PLANNING CONSULTATION RESPONSE

Application No	2025/1040
Proposal	Demolition of the existing bungalow to create additional car park spaces and school forest garden, including associated landscaping works.
Address	School Bungalow, Worsbrough Bank End Primary School, Underwood Avenue, Worsbrough Dale, Barnsley, S70 4AZ.
Date of Consultation Reply	23/01/2025
Consultee	Edward Jowett (Tree Officer)

Drawing title
TREE CONSTRAINTS PLAN

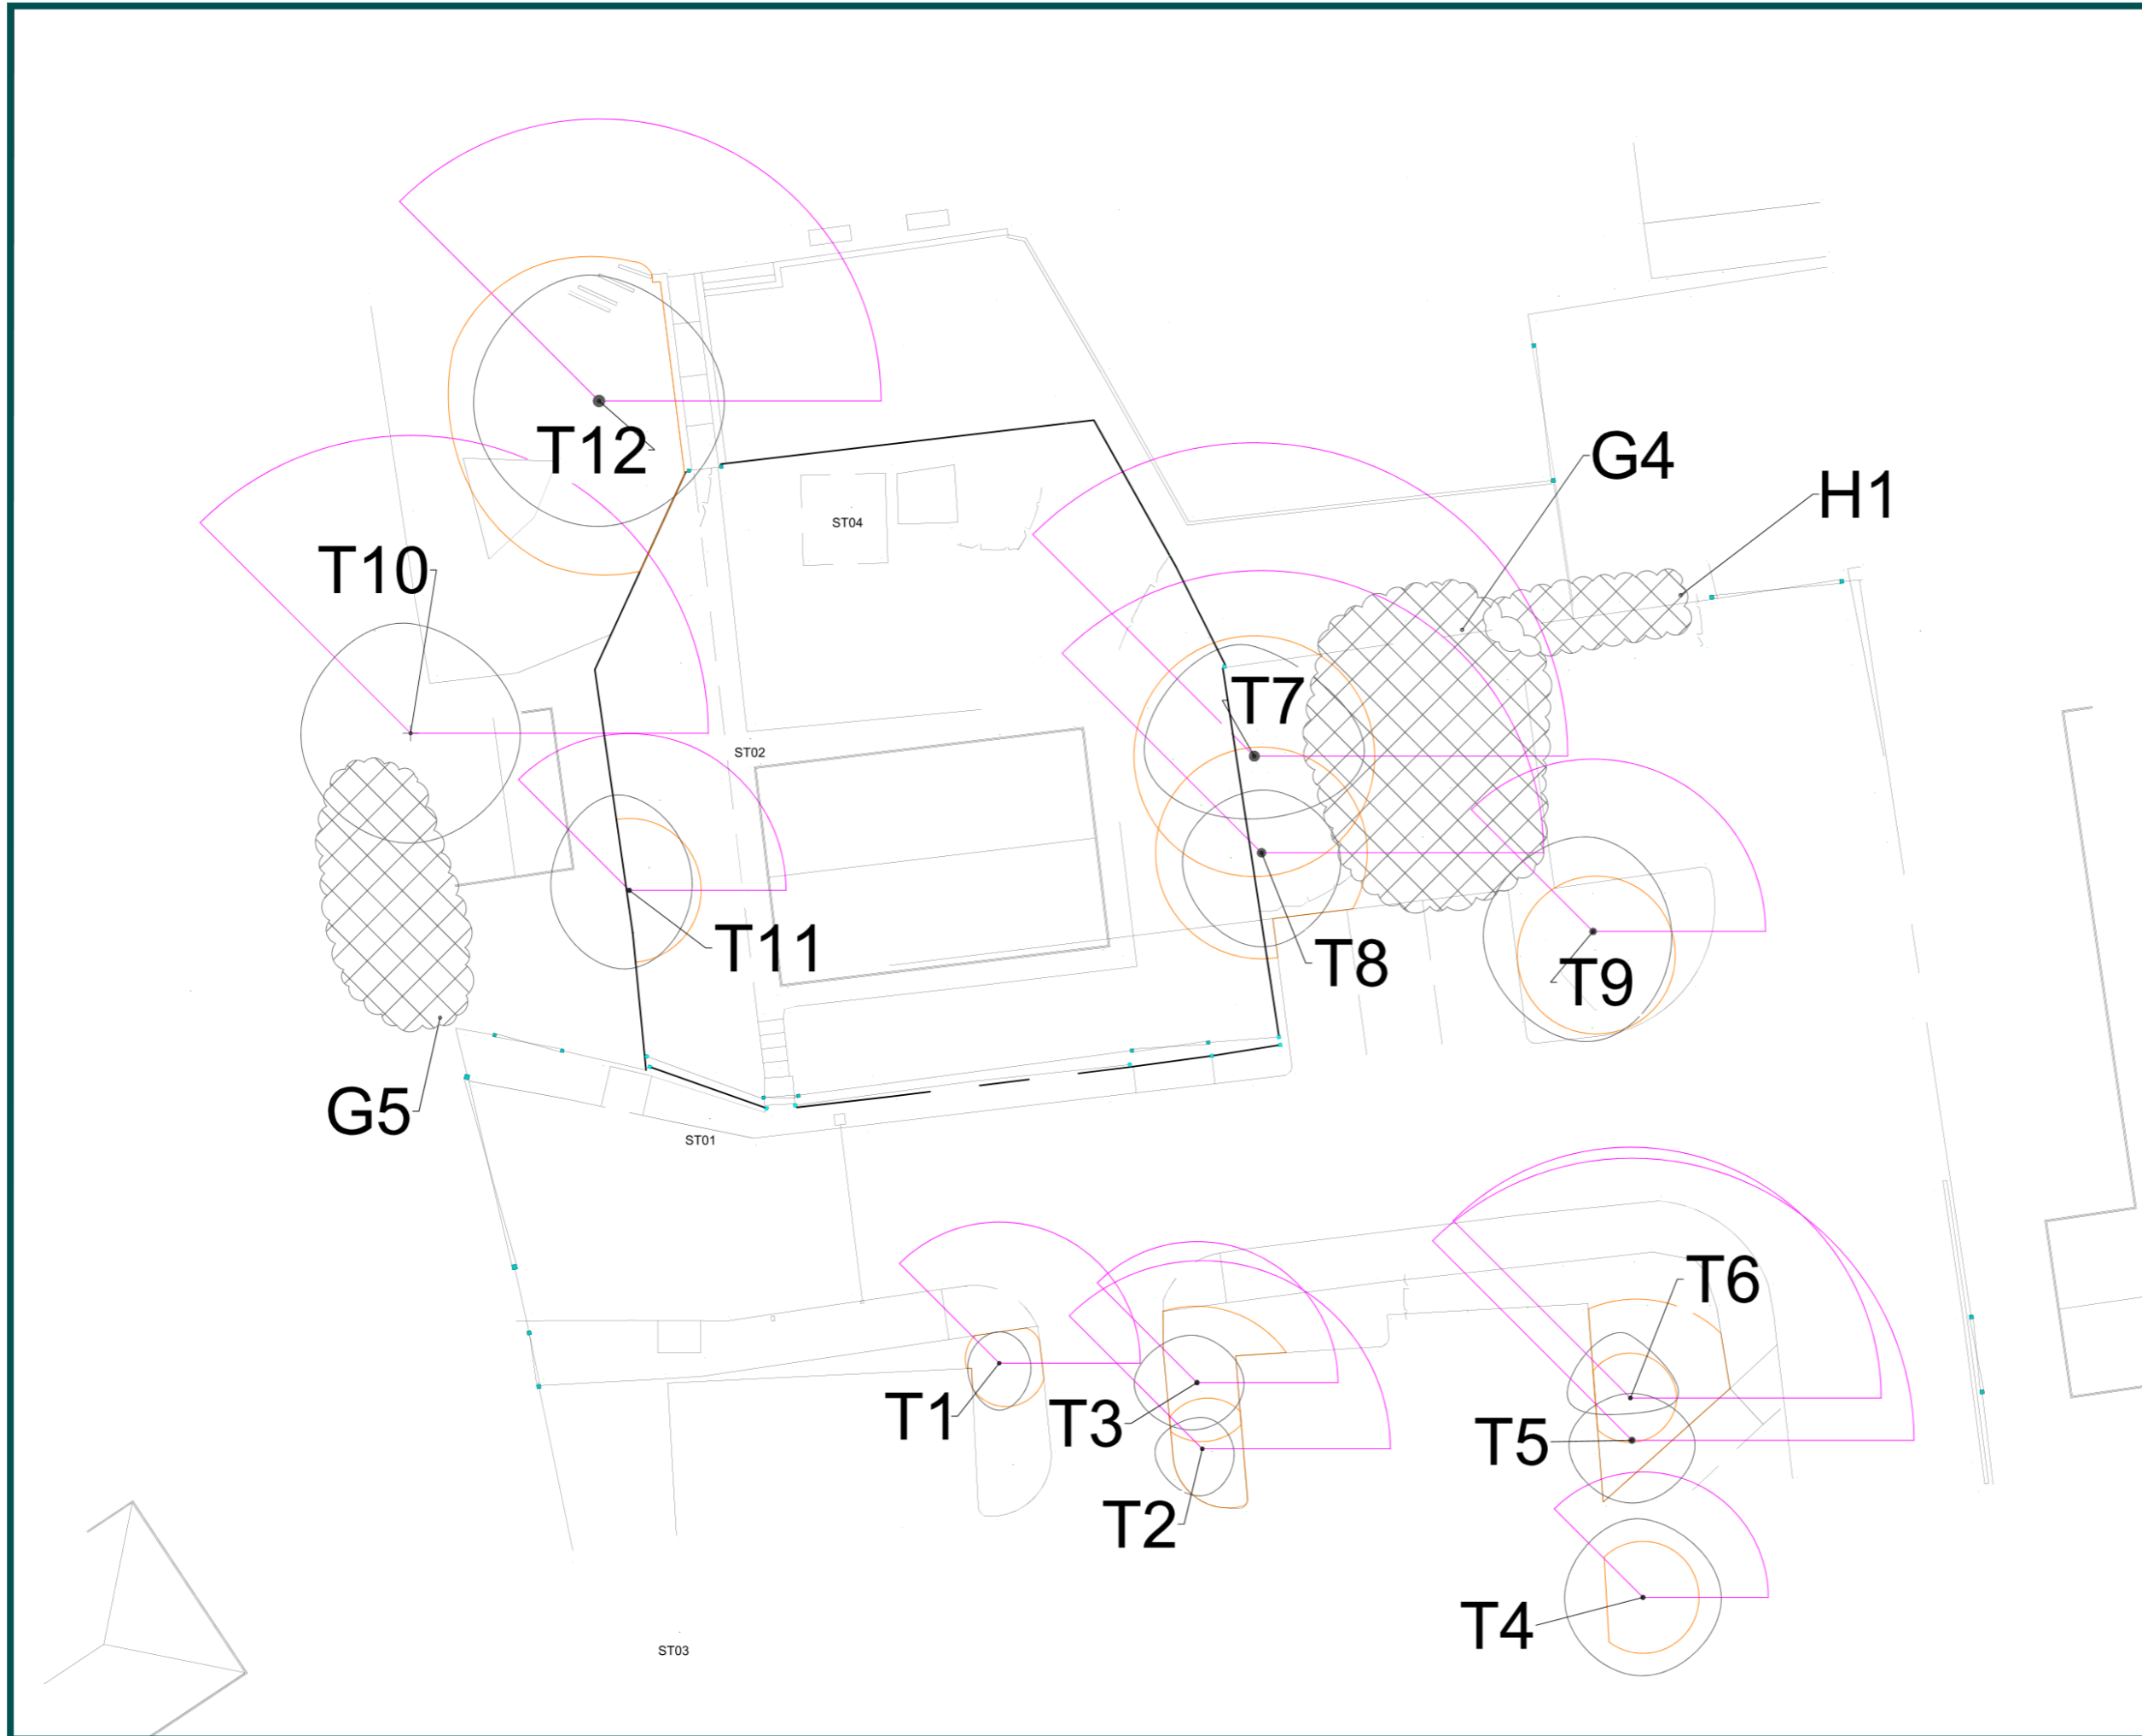
The information provided in arboricultural terms regarding this application is very limited with only a survey schedule and a constraints plan being provided. The landscaping plan shows that a couple of trees and one group will be retained but this is not entirely clear. I would therefore ask that the details of the tree retention and removal proposed be provided along with the justification/reasoning why the trees removals proposed are required.
